August 1, 2024

**RE: Comment Response Letter for:
Frazee Construction Warehouse
PPR2425: 2825 E. Las Vegas Street Site Development Plan
Tax Schedule Number: 6433400016**

Please accept this Comment Response Letter as part of Drexel Barrell's resubmittal to El Paso County regarding the aforementioned project. Comments with corresponding responses (in blue) have been addressed below.

COVER
SHEET

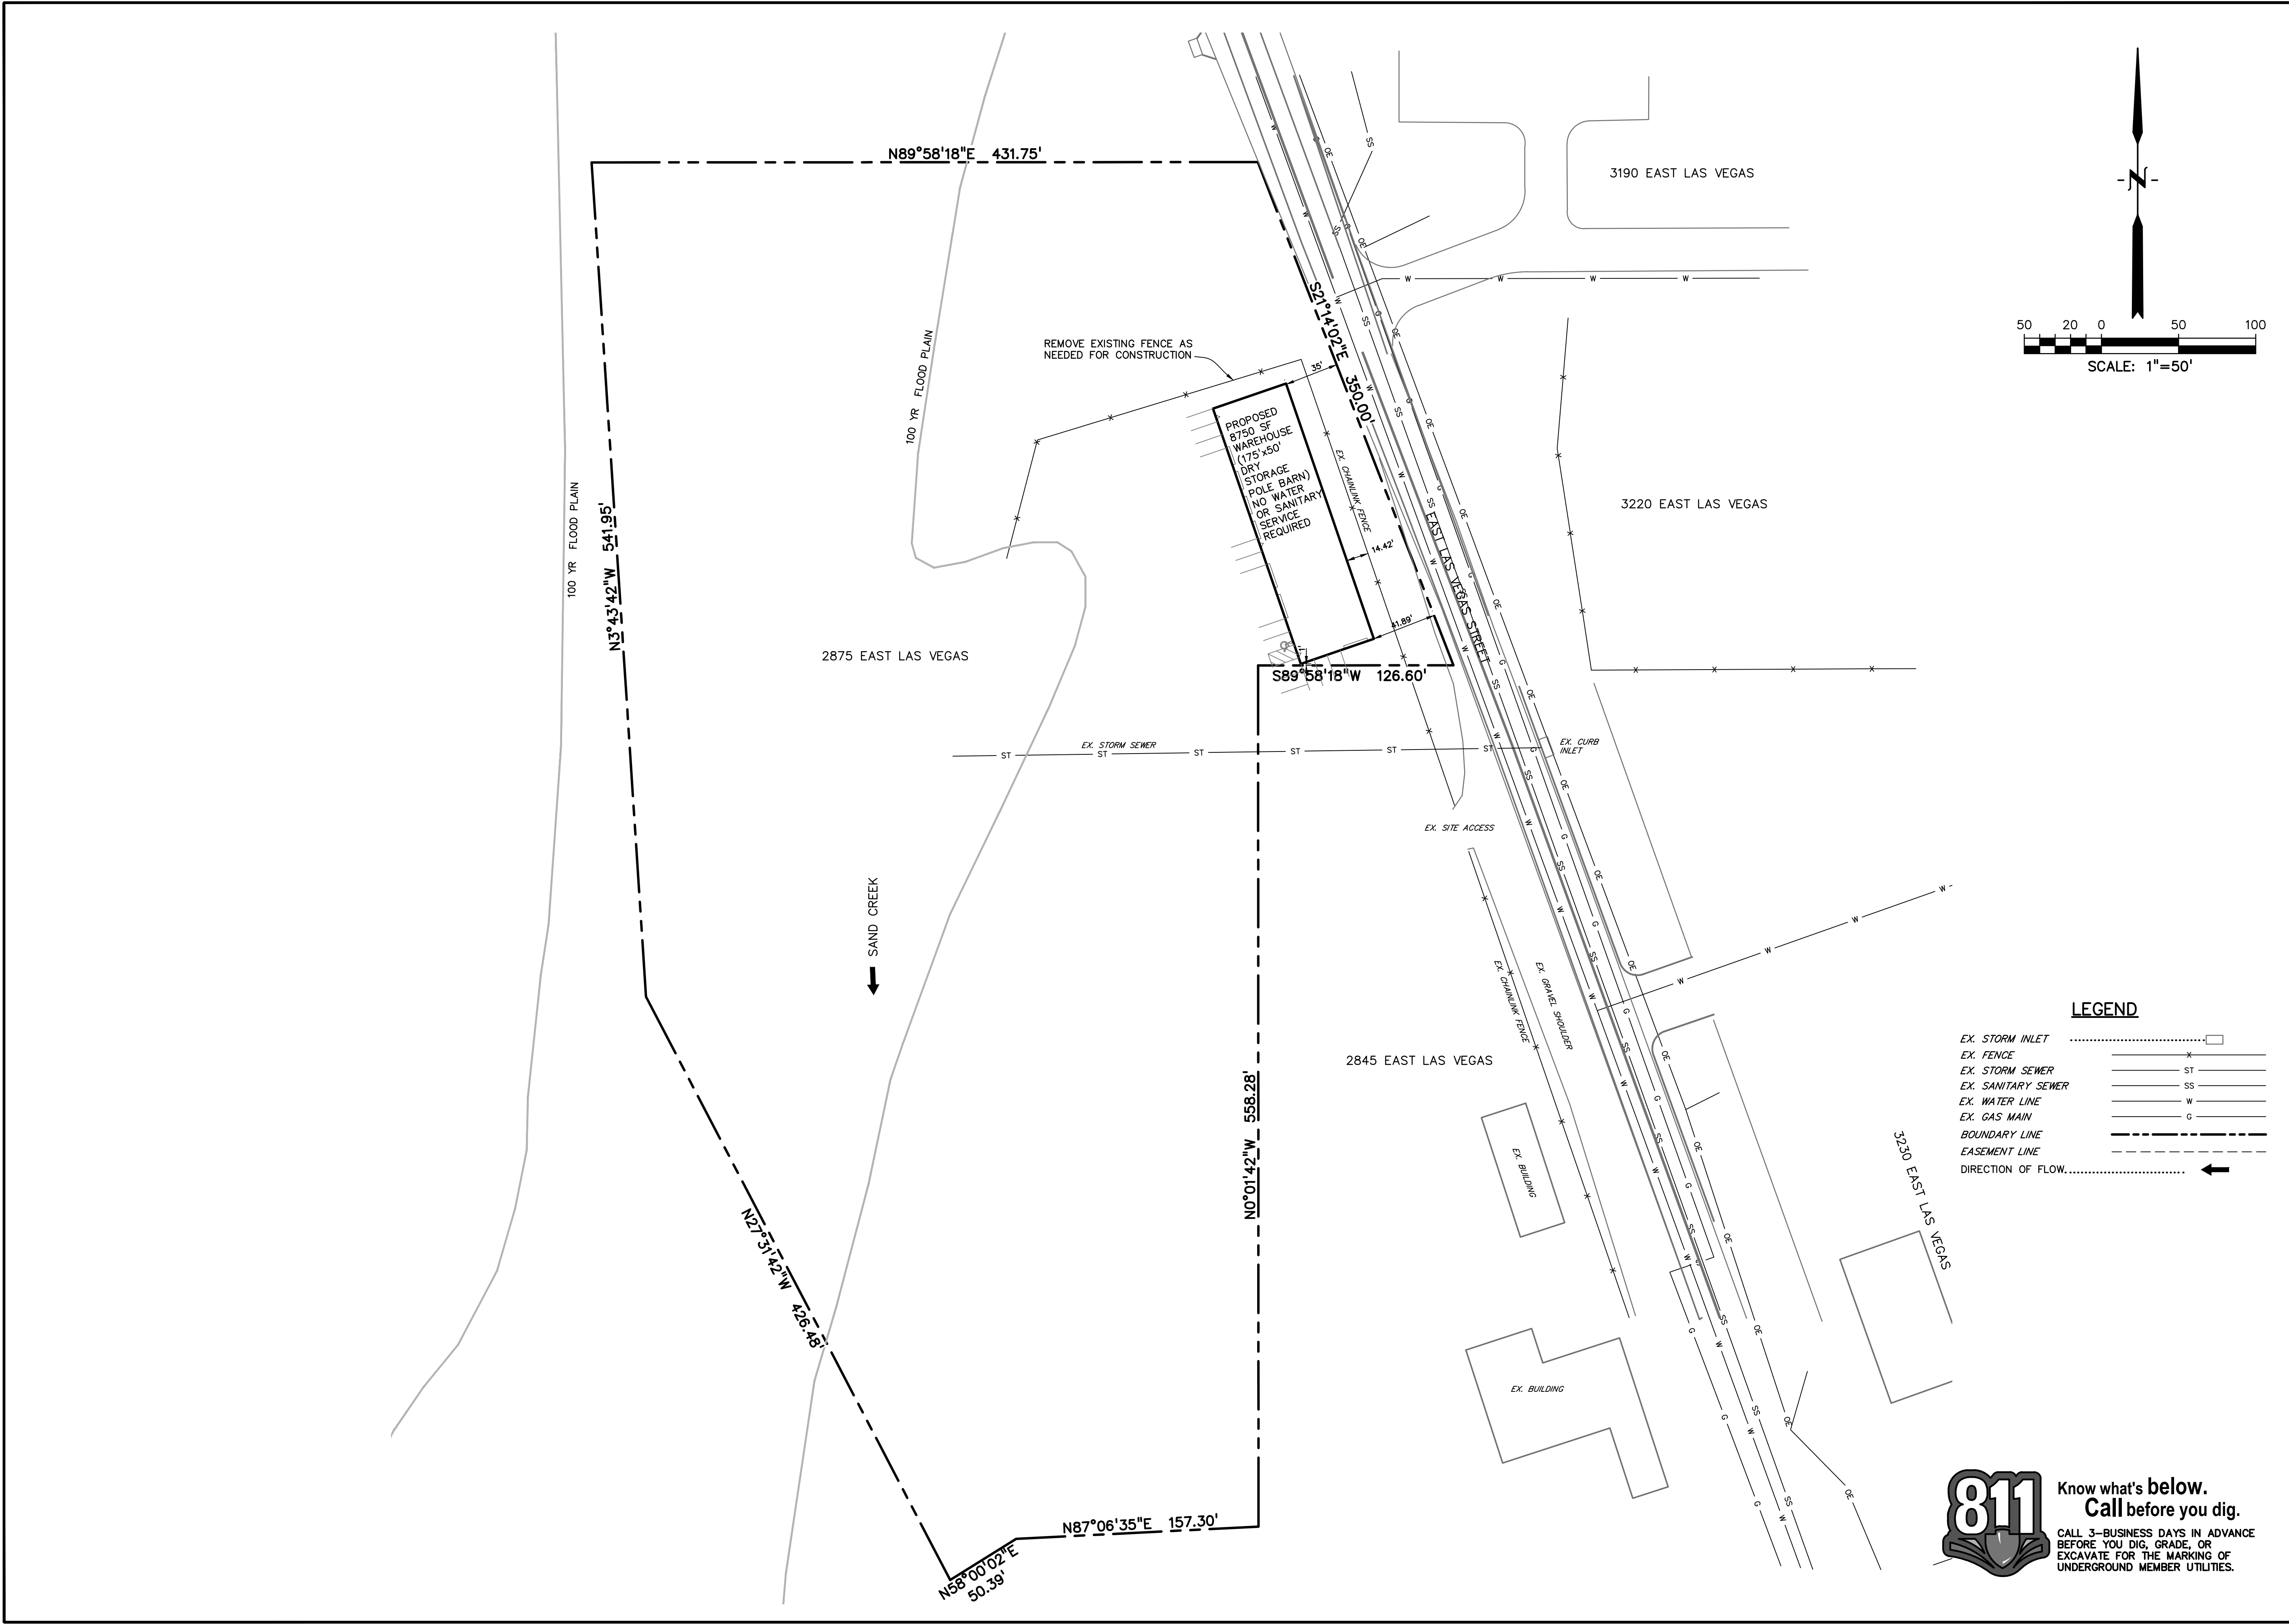
Pikes Peak Regional Building Dept: 07/29/24
Enumerations has the following comments:
1. Enumerations has assigned the address of 2825 E. Las Vegas St. for this new commercial building. The plan should be updated to show this address.
2. The address of 2825 E. Las Vegas St. should be used when submitting building plans for permitting.

Comments have been addressed and revisions are included.
